Re: Planning Application 20/0185

Address: 1 Brookfield Mellor BB2 7JN

Description: Proposed two storey extension to rear and new first floor window in the gable. Demolition of outbuilding.

0 PROPOSED GROUND FLOOR

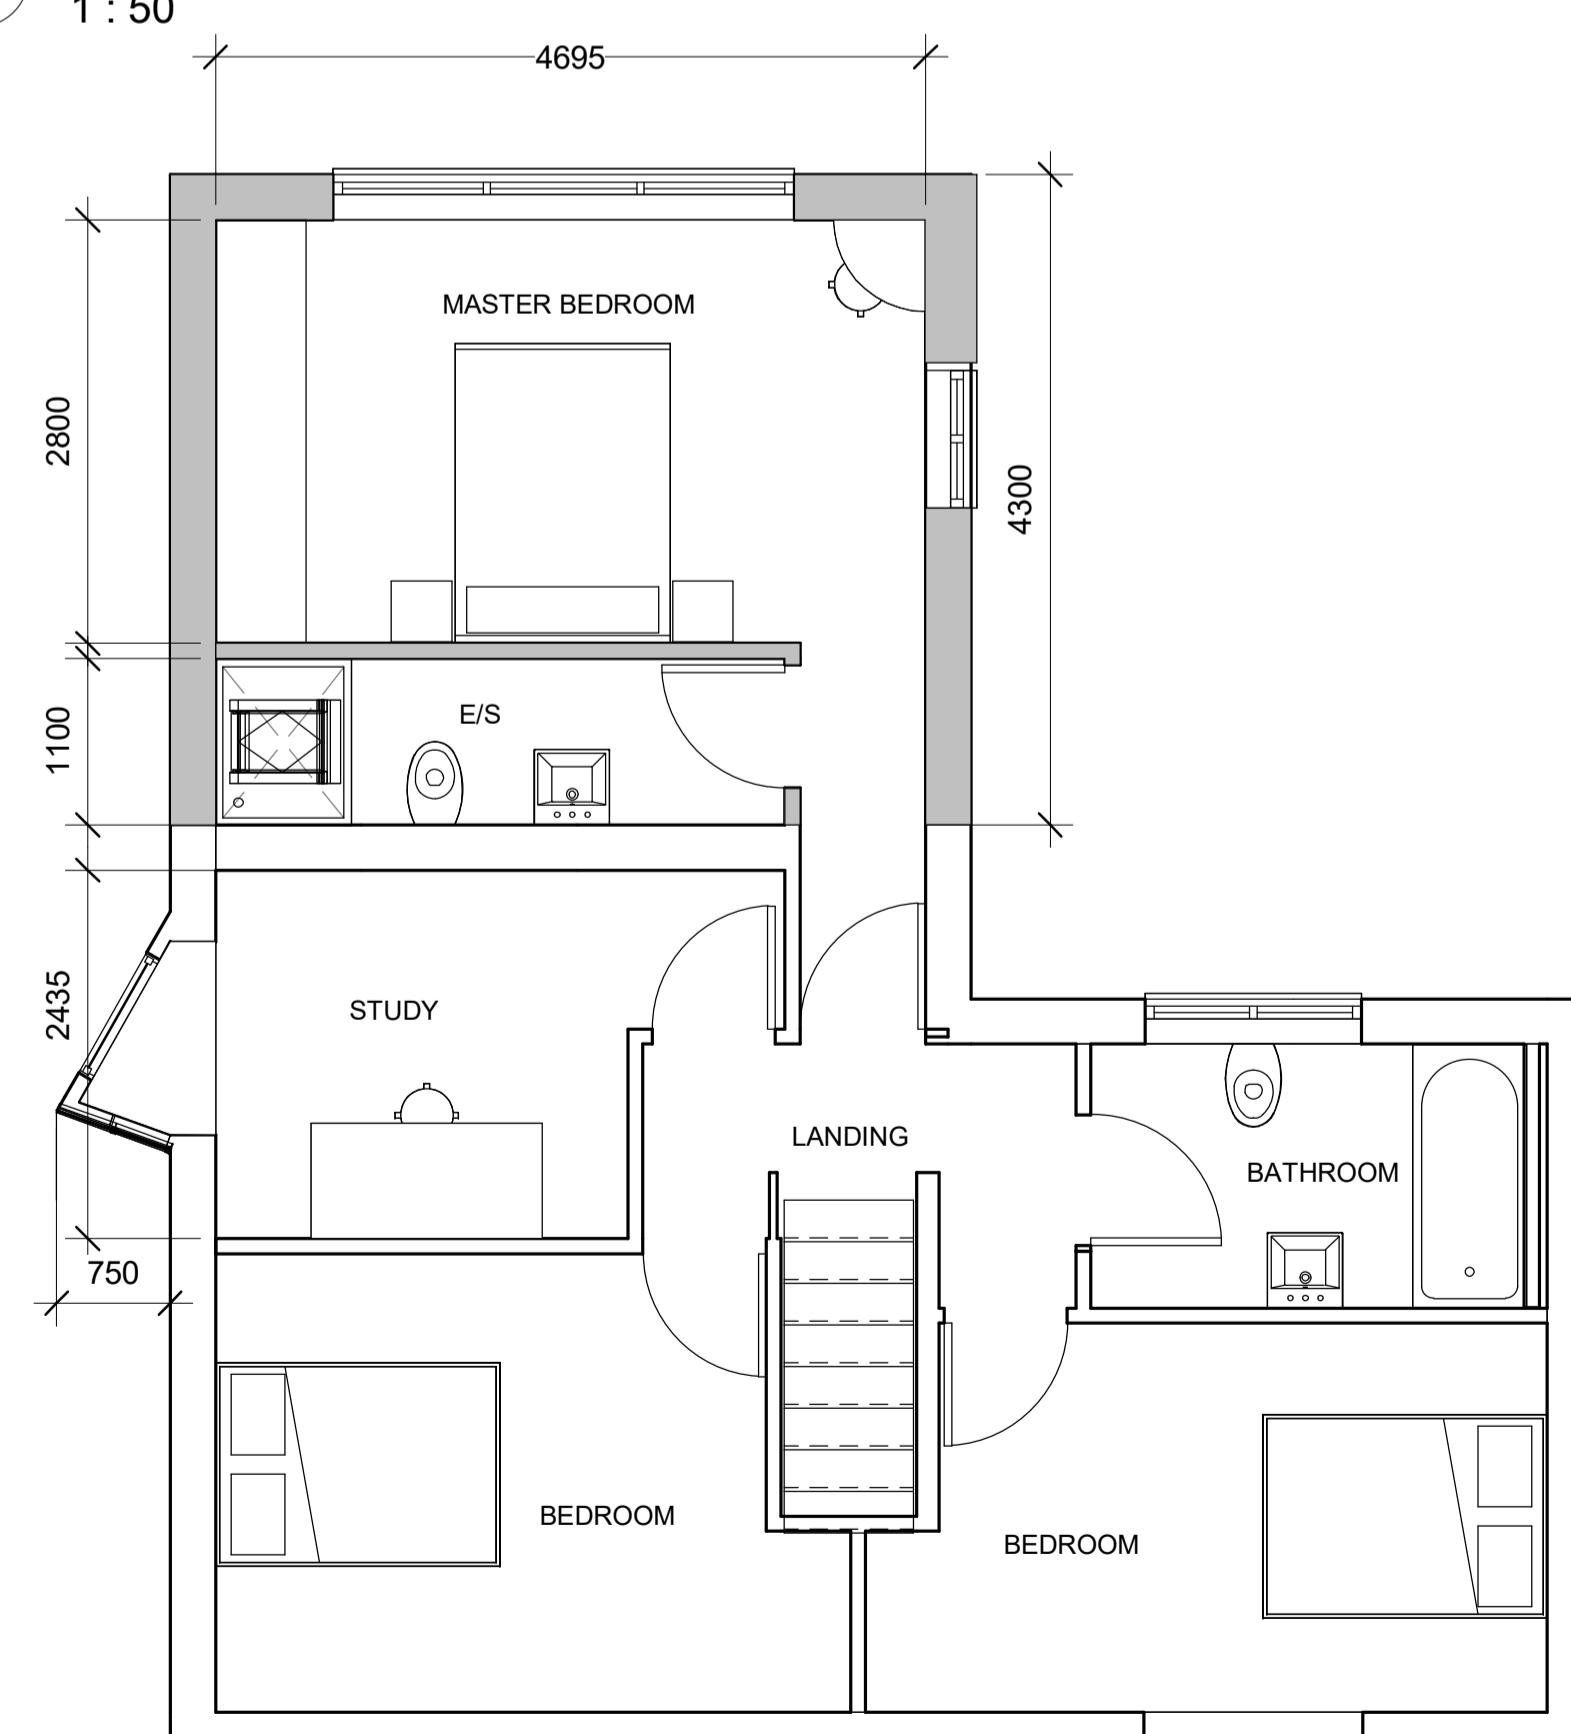
It is expected that the existing driveway to the front of the dwelling is to be closed off and the lowered crossing raised.

from the edge of the carriageway along the boundary with 3 Brookfield and a point 10m along the curtilage of the dwelling from the boundary with 3 Brookfield. **Reasons:** To ensure adequate visibility at the driveway
